From: West Planning
Sent: 21 July 2026 09:43
To: DC Admin
Subject: FW: FAO Morgan Braithwaite re: 2026/HHPD/91607/W

We are writing regarding the proposed rear extension at 36 Moor Park Avenue, adjacent to our property at 38 Moor Park Avenue.

DRAWING TITLE
Proposed Plans

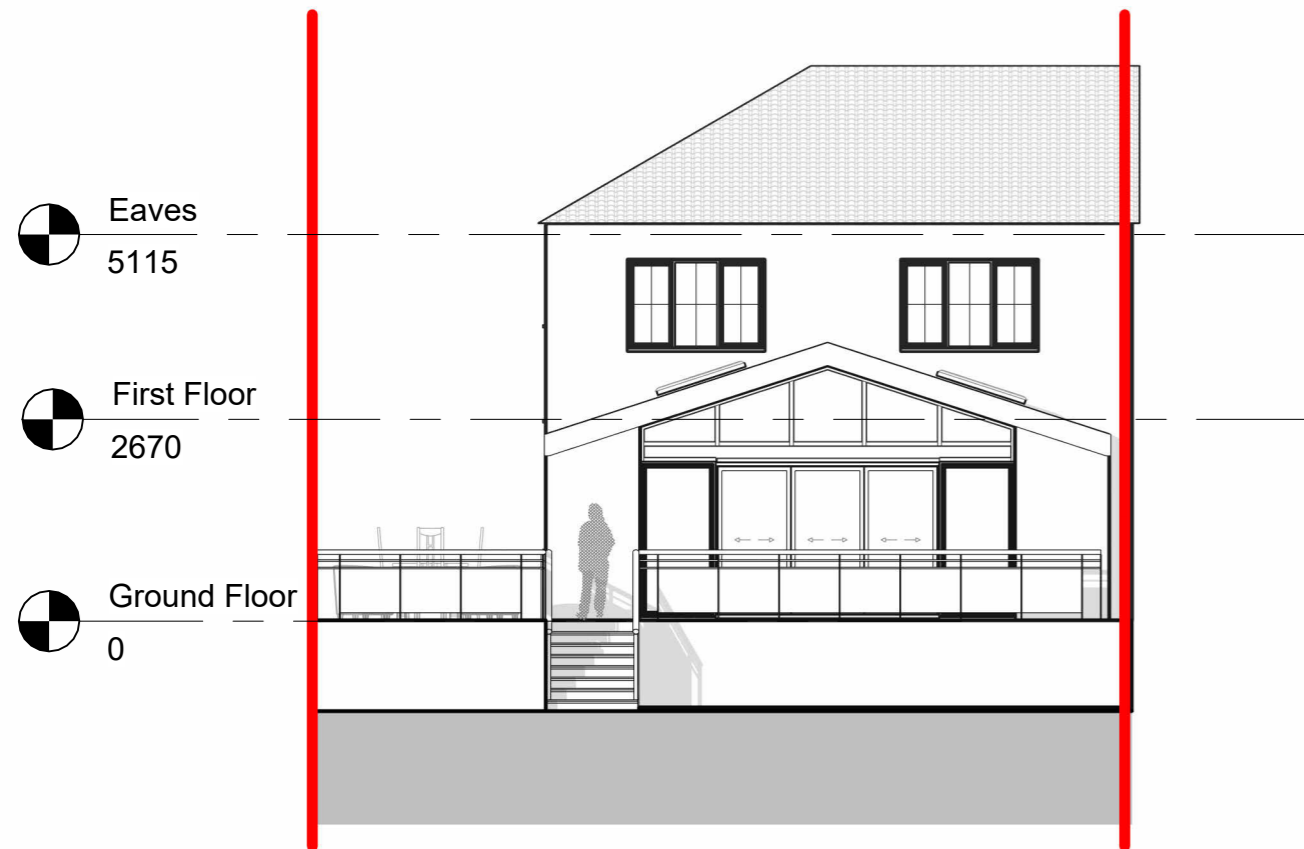
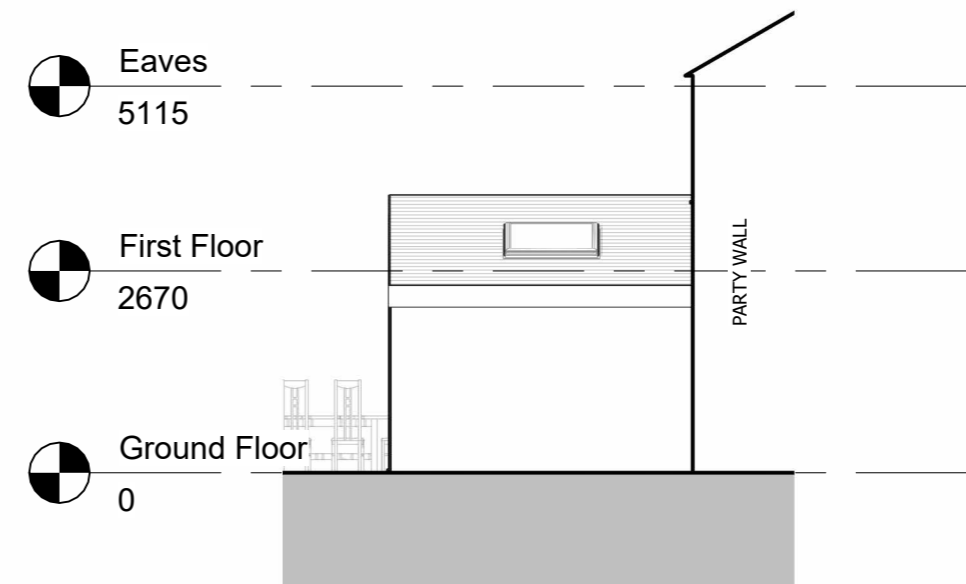
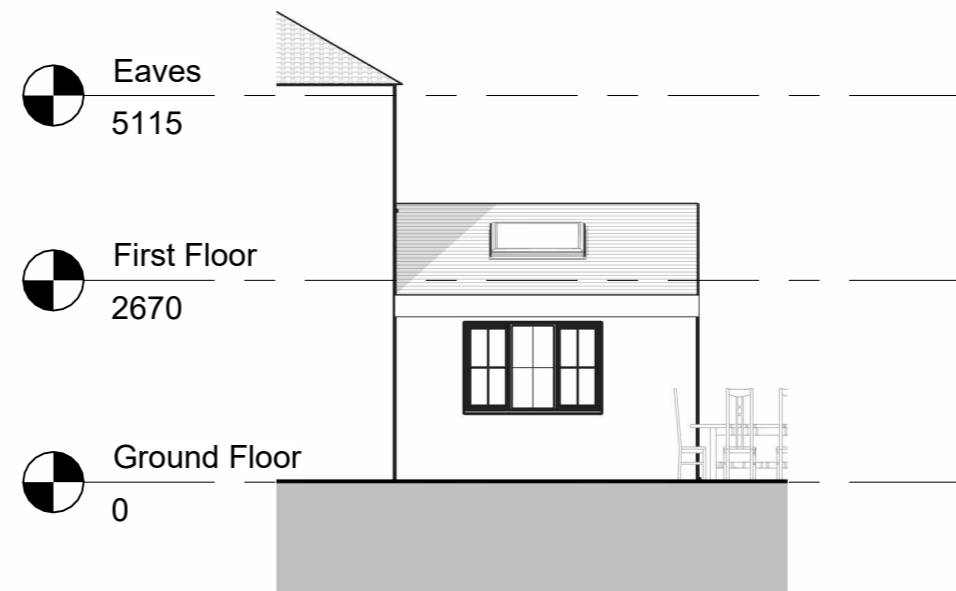
- **Loss of light** to our primary living space and adjoining dining area, both of which rely on rear-facing windows for natural daylight; and
- **The overbearing and dominating impact** of the extension, given its depth and its position directly on the shared boundary.

We are concerned that the scale and siting of the extension will result in a noticeable reduction in daylight to these rooms and create a sense of enclosure that is materially harmful to the enjoyment of our home. In our view, this goes beyond what would reasonably be considered an acceptable impact between neighbouring properties.
